Application no: **3/2021/1022**

Address: **Loft Shay Farm Clitheroe Road Ribchester PR3 2YQ**

Proposal: **Proposed single storey extension, garage and modifications to existing dwelling as approved under planning reference 3/2021/0670.**

Drawing file: planx_downloads / 21_1022_PROW_Map.pdf

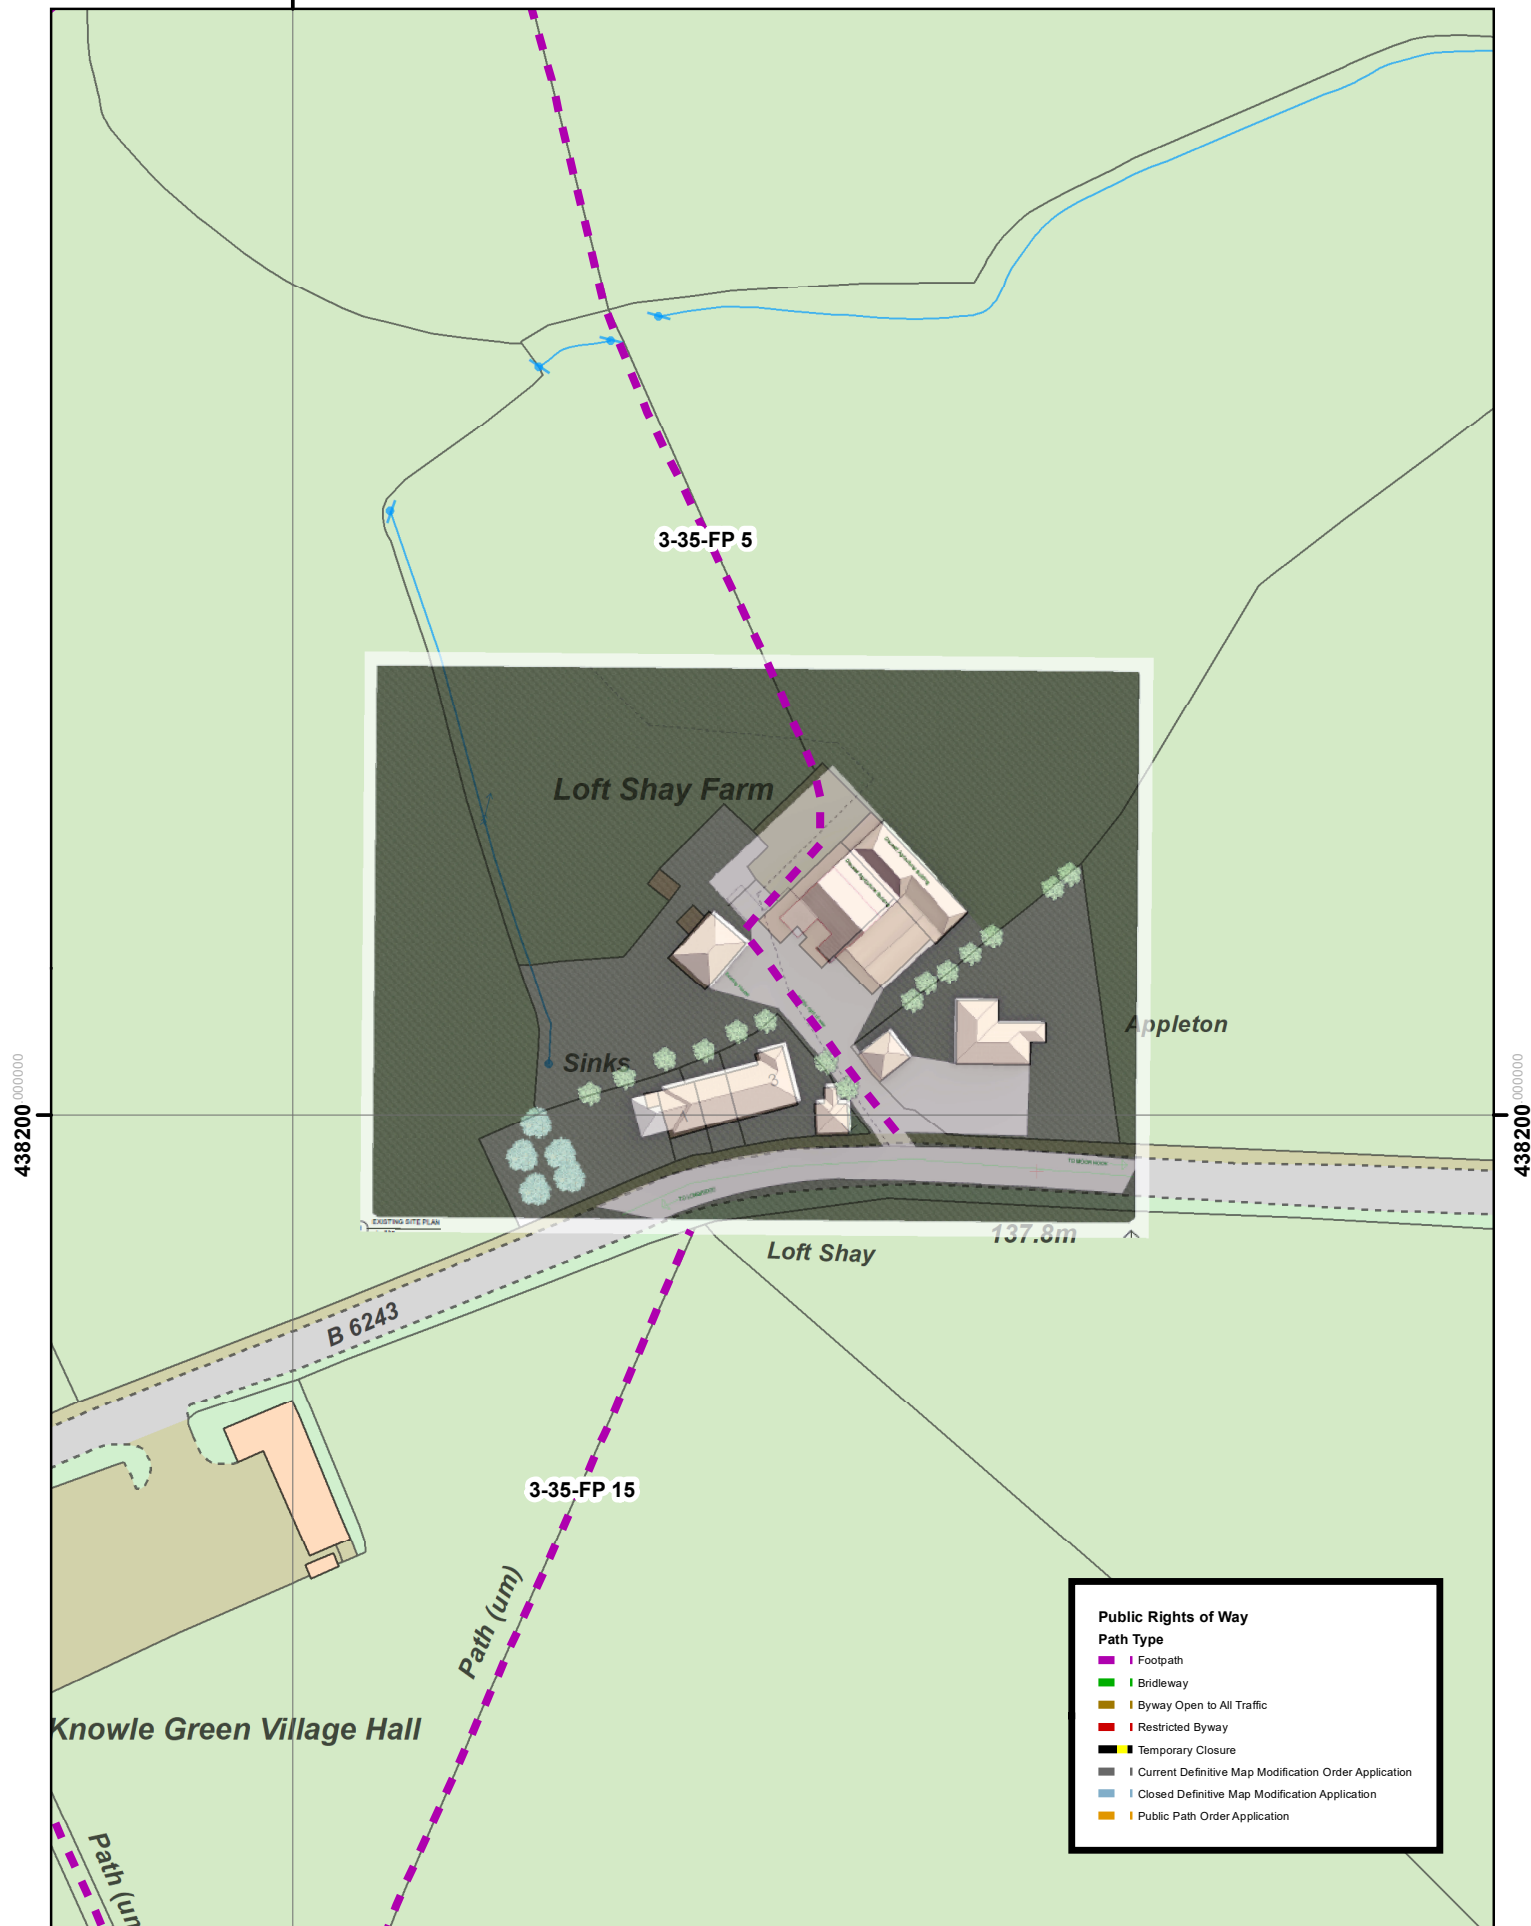
The existing PROW which is adjacent to the site access and goes through the existing agricultural building, which will be demolished and replaced with the single storey extension, leads out of the site via an adjacent field to the rear of the dwelling.

In response to the proposal, the Applicant is proposing to divert the PROW, as shown on Peter Hitchen drawing number A1.2, to the adjacent field.

However, the LHA require further information regarding where the diversion will connect to the existing PROW. The LHA advise the Applicant to connect the diversion to the existing PROW directly outside the site. This should be shown on a revised plan.

Not only this but the LHA require the landowner's permission for the diversion of the PROW into their field. Even though the LHA are aware that the PROW goes through the existing field, permission is still required from the landowner to divert it.
